Our Ref: EF19/12260

### City of Gosford Design Advisory Panel

Proposal: Northside Private Hospital  
Panel Meeting: 28/05/2019

### Attachment A – Design Review Panel Advice

STAGE 1, GF + LVL 1

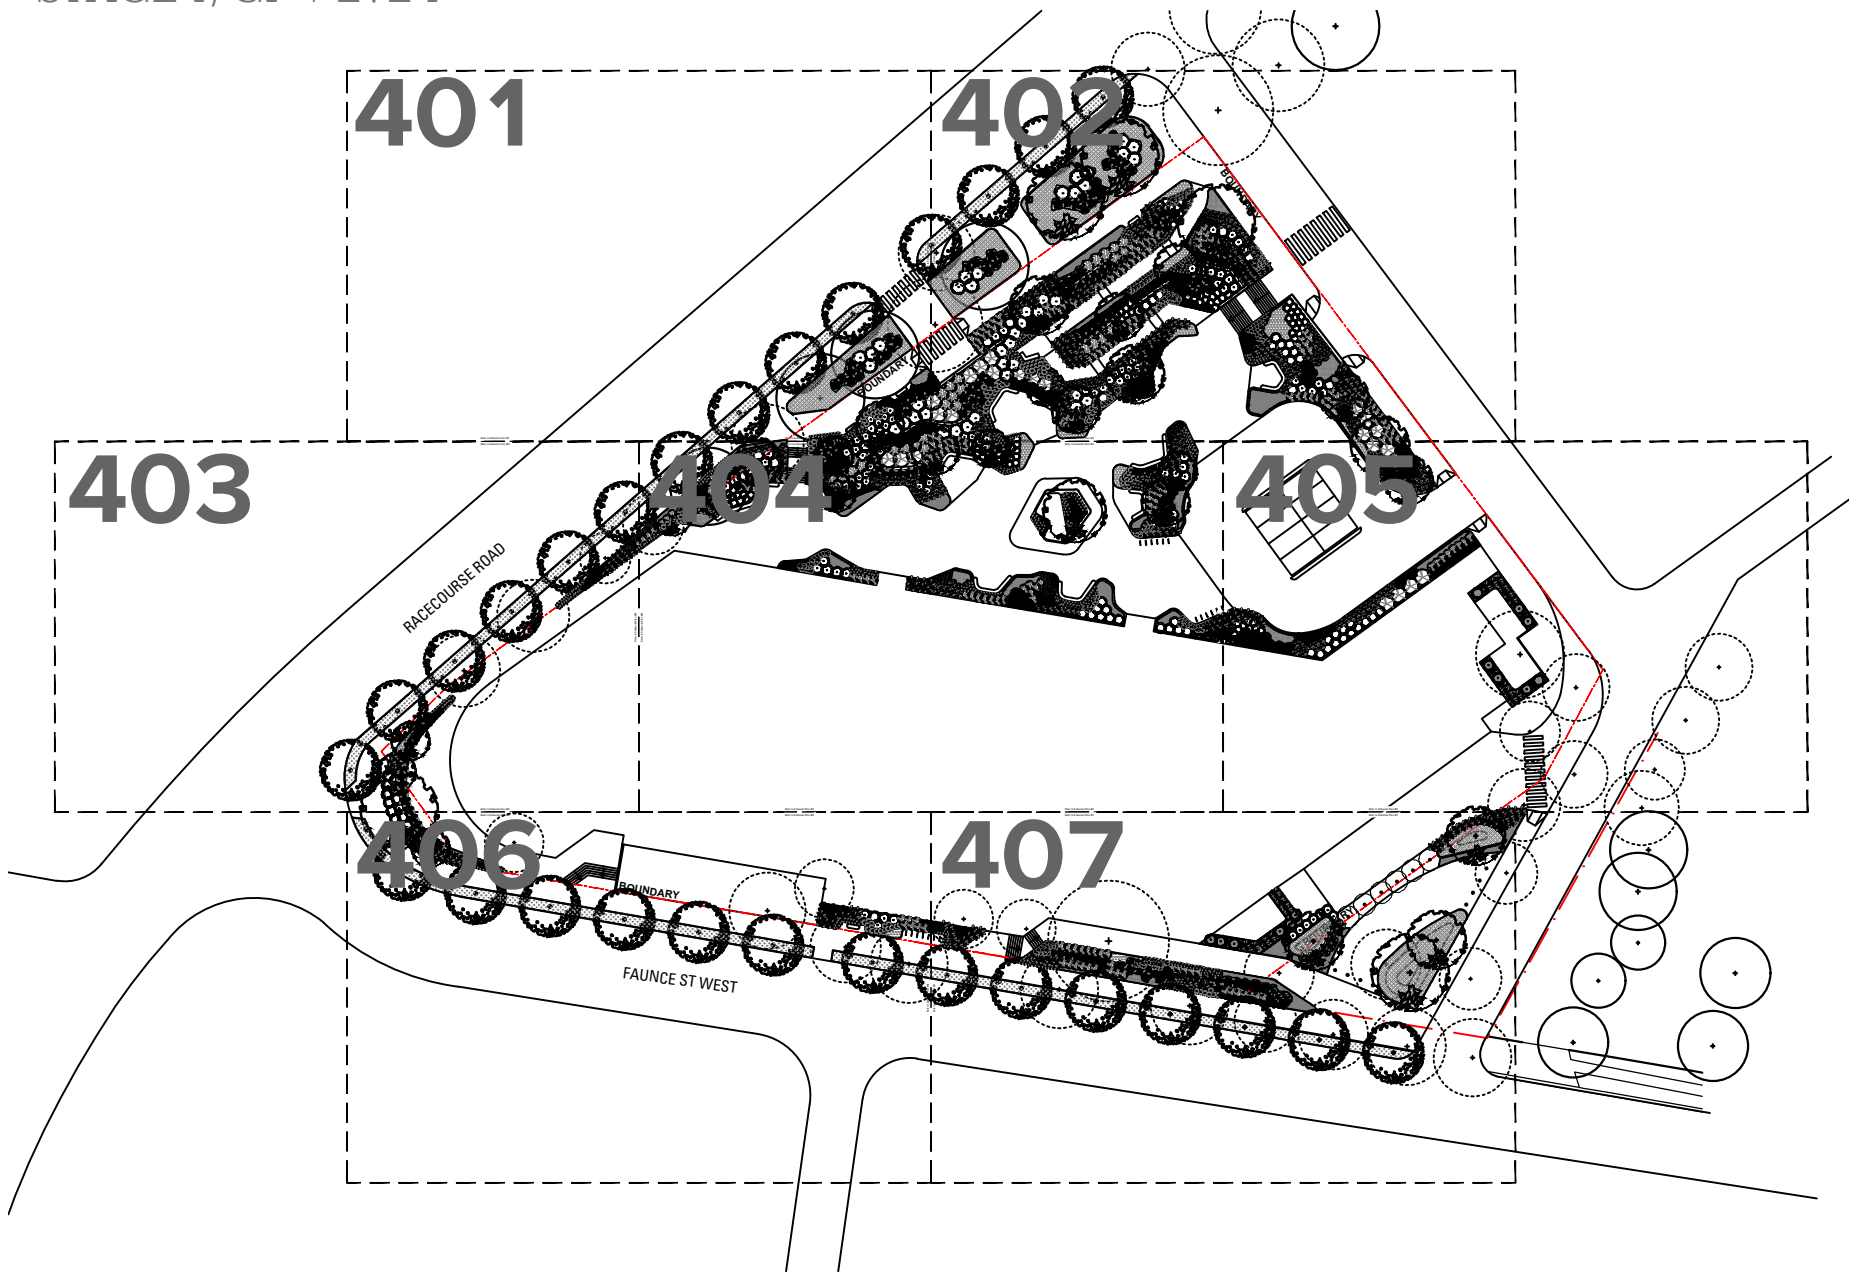
8. The Panel suggests the drop-off road be a U-shape rather than a donut to reduce impact of fall in contours and need for multiple, high retaining walls. There should be increased landscaping provided in the front forecourt area.

11. The Panel suggests that, in the roof-top courtyard, the proponent consider the adjacent walls/rooms to maximise the views and feel of the space.
12. The Panel notes the basement extends under most of the building and plaza. In the final design, ensure that the building is set back enough for deep soil planting and consider punching through areas of the basement to allow for plantings along the green spine.
